Ribble Valley Borough Council  
Housing & Development Control

Application no: **3/2020/0791**

Address: **Land to NW of the Old Police House Preston Road Ribchester PR3 3XL**

Proposal: **Erection of one 2 storey detached dwelling house with associated parking and landscaping works.**

## 8. Access

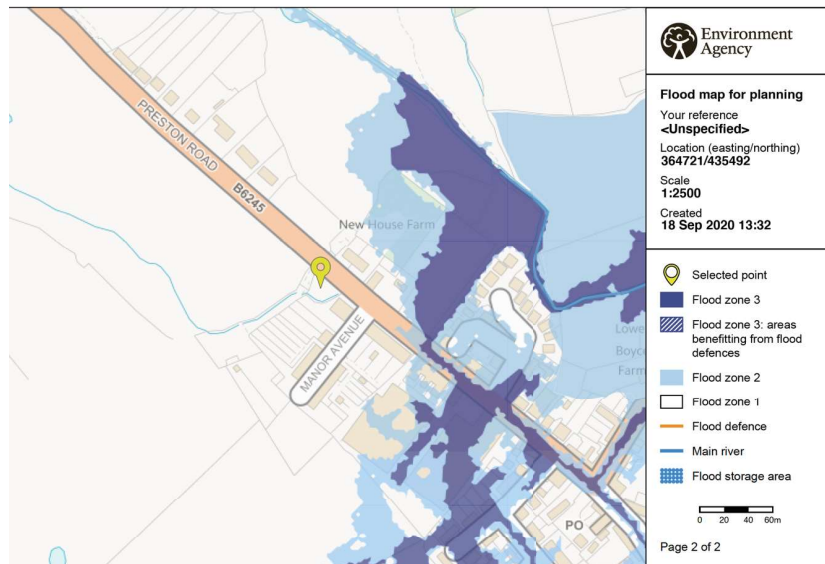
The proposed new access point would need to be 3m in width, bound with an approved surface material with the visibility splays remaining free and clear from obstruction at all times in perpetuity of the development.

I ask the plans are revised detailing the above.
